COMMUNITY DEVELOPMENT DEPARTMENT  
80 Columbia Avenue ♦ Marysville, WA 98270  
(360) 363-8100 ♦ (360) 651-5099 FAX

July 25, 2022

**Re: PA22-019 - Groundhog PRD – Technical Review 2**

PROSPECTOR 6
5110 83RD AVE NE
MARYSVILLE, WA 98270

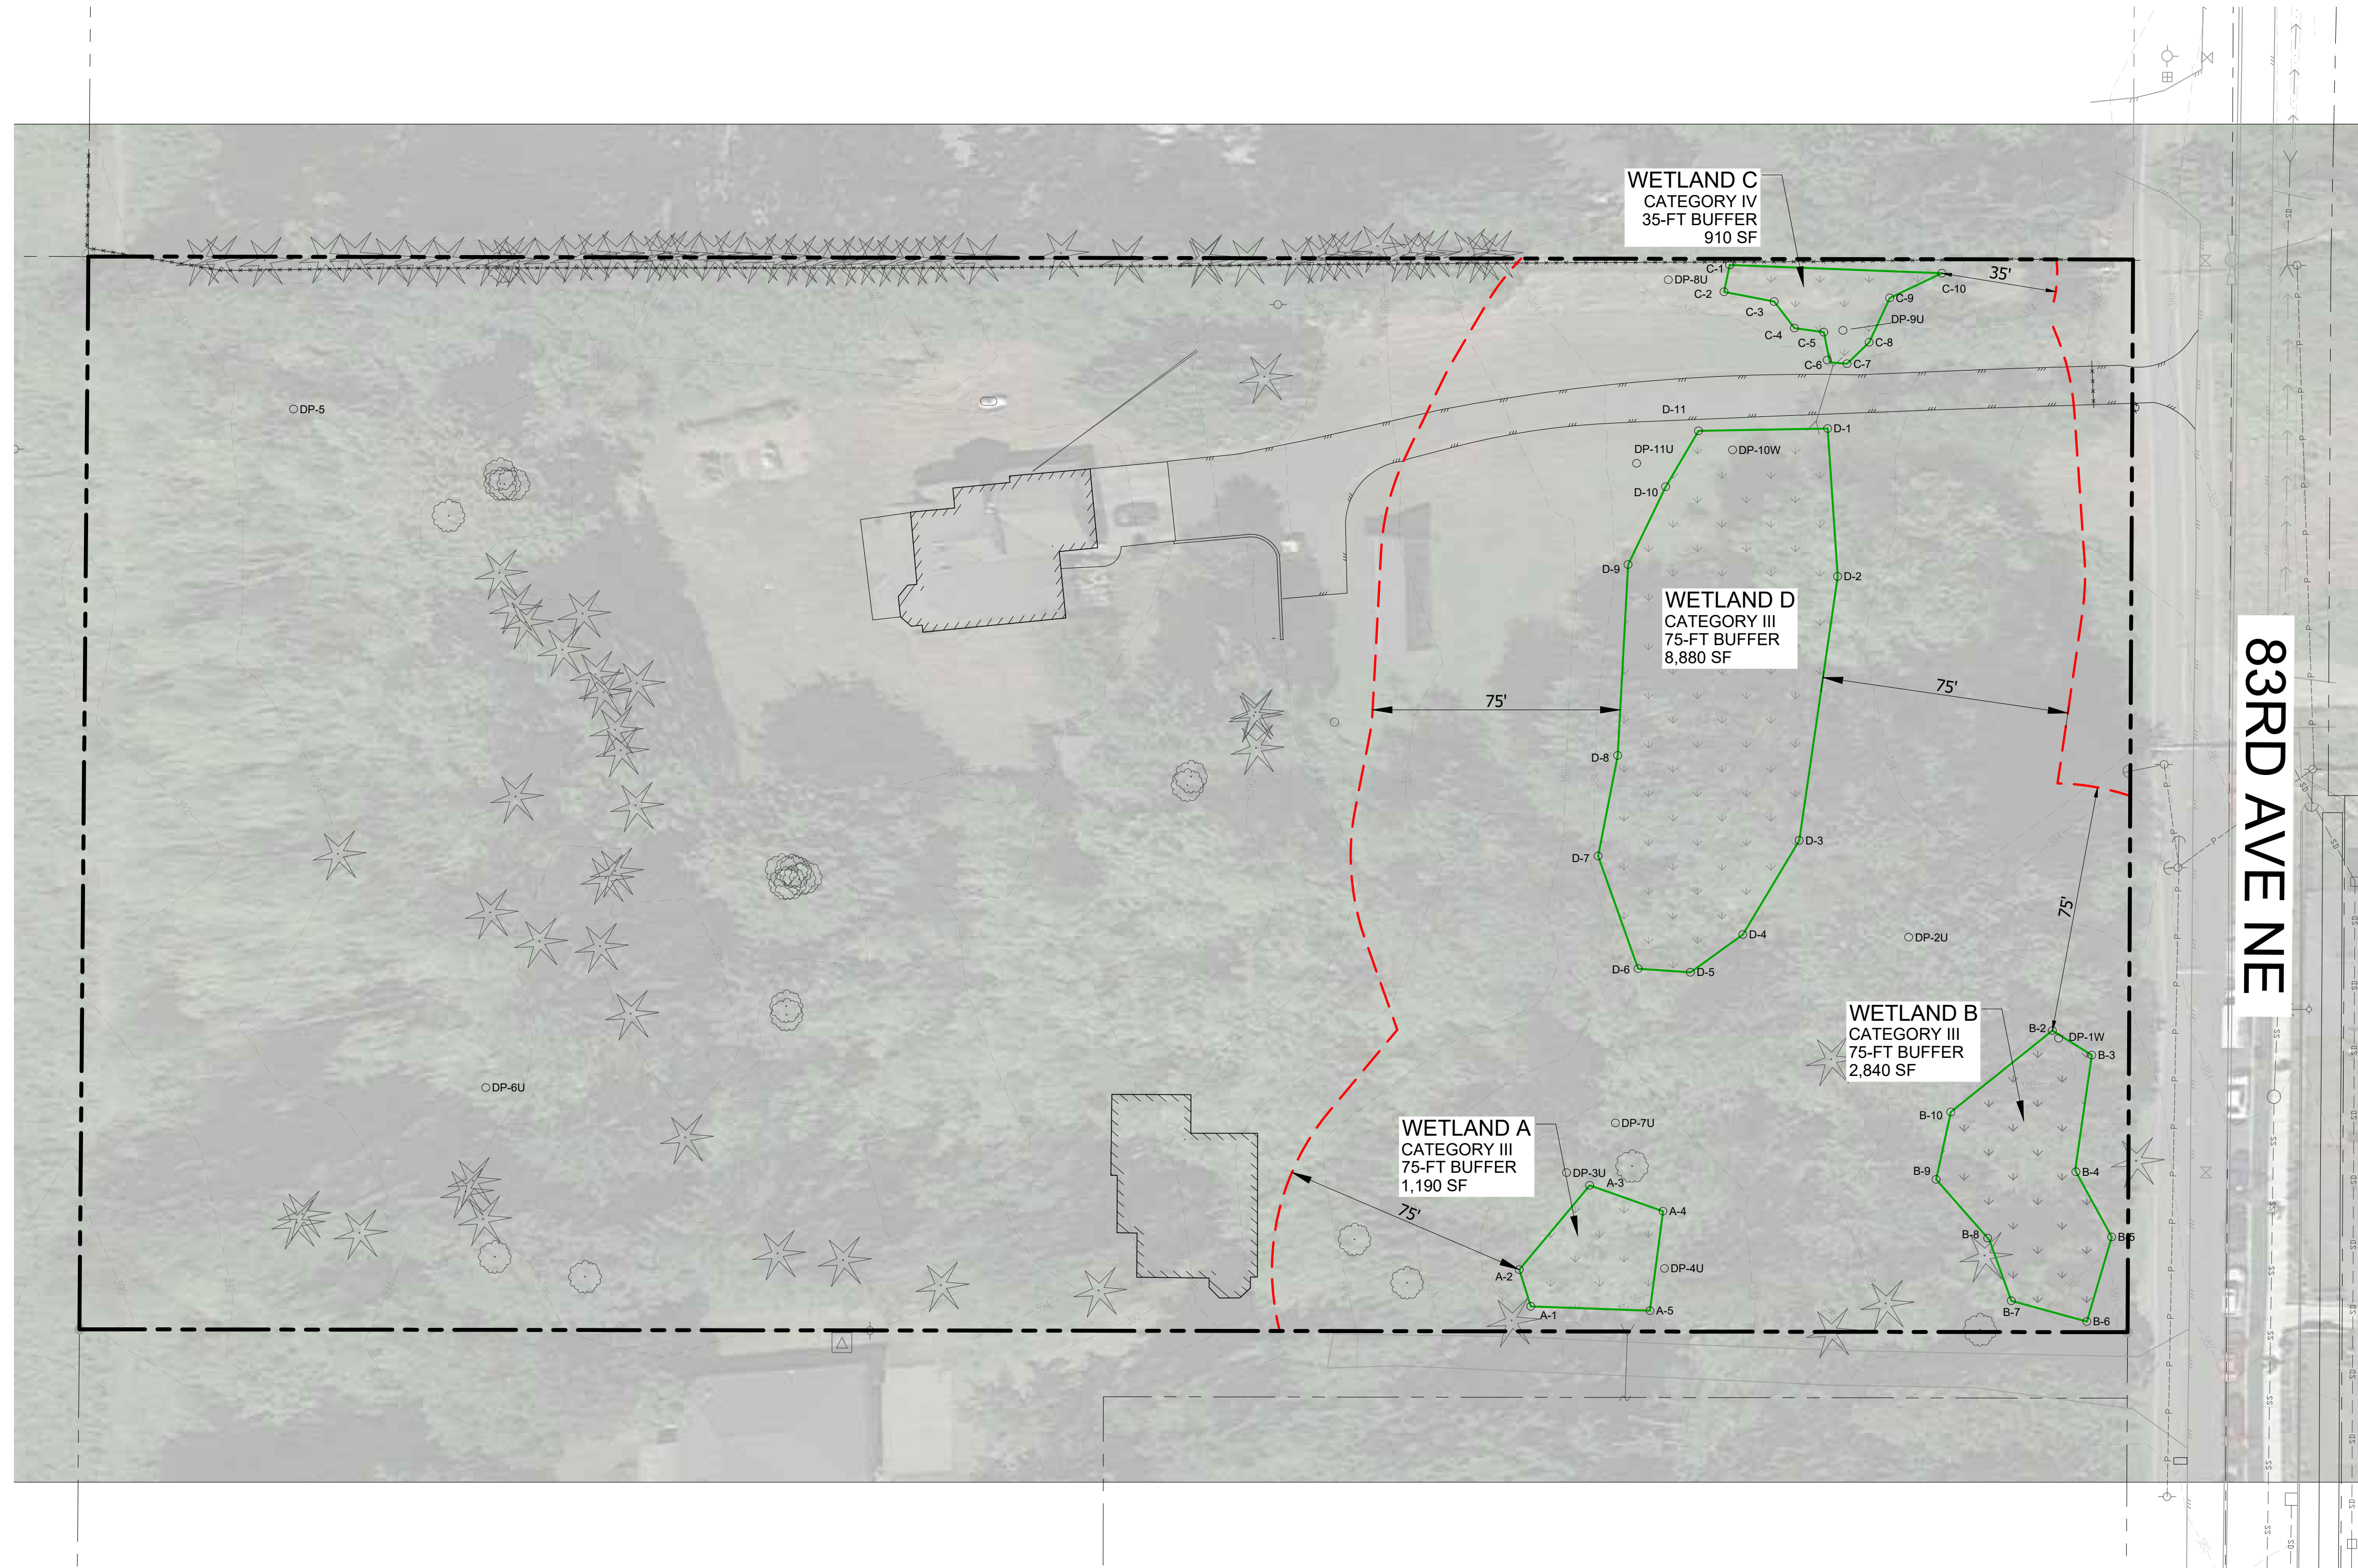
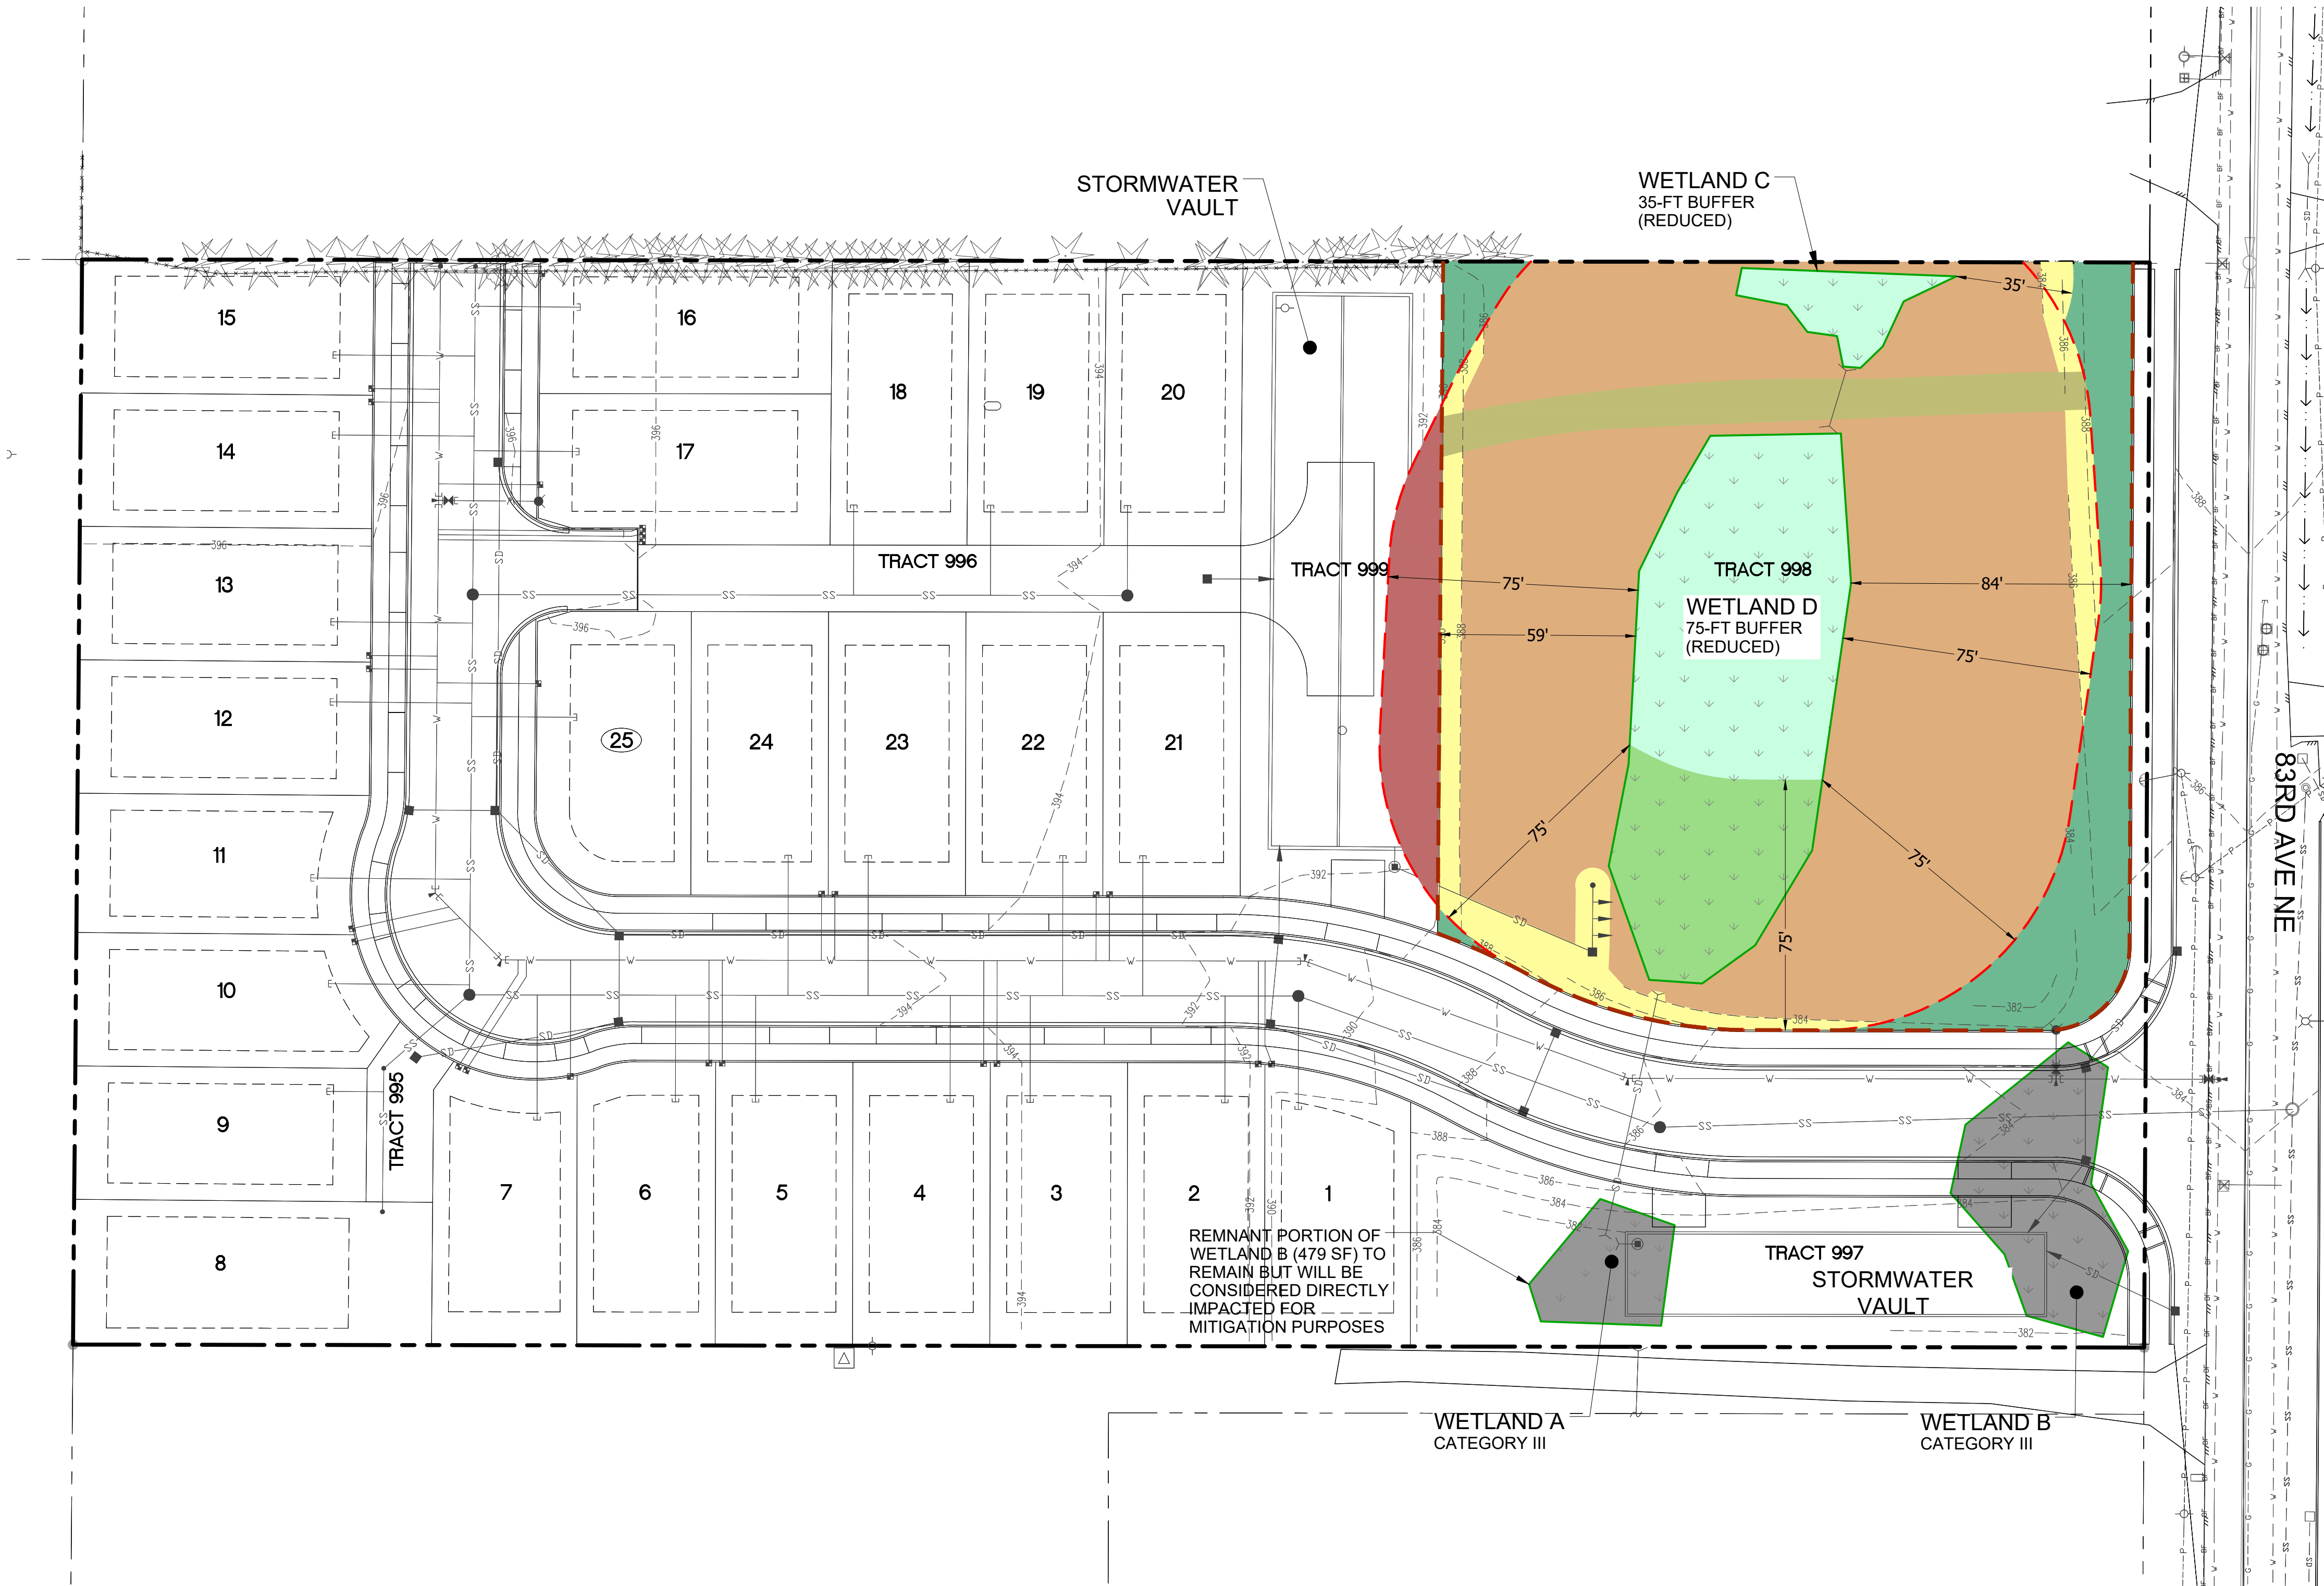
1. Pursuant to MMC 22E.010.120(3)(c) for wetland mitigation ratios, Category III wetlands require mitigation of ratios of 2:1 for enhancement areas along with 1:1 for re-establishment or creation of buffers.

Provide an addendum to the Conceptual Mitigation Plan that clarifies that these required ratios would be satisfied through onsite compensatory mitigation and off-site contribution to the SBMB.
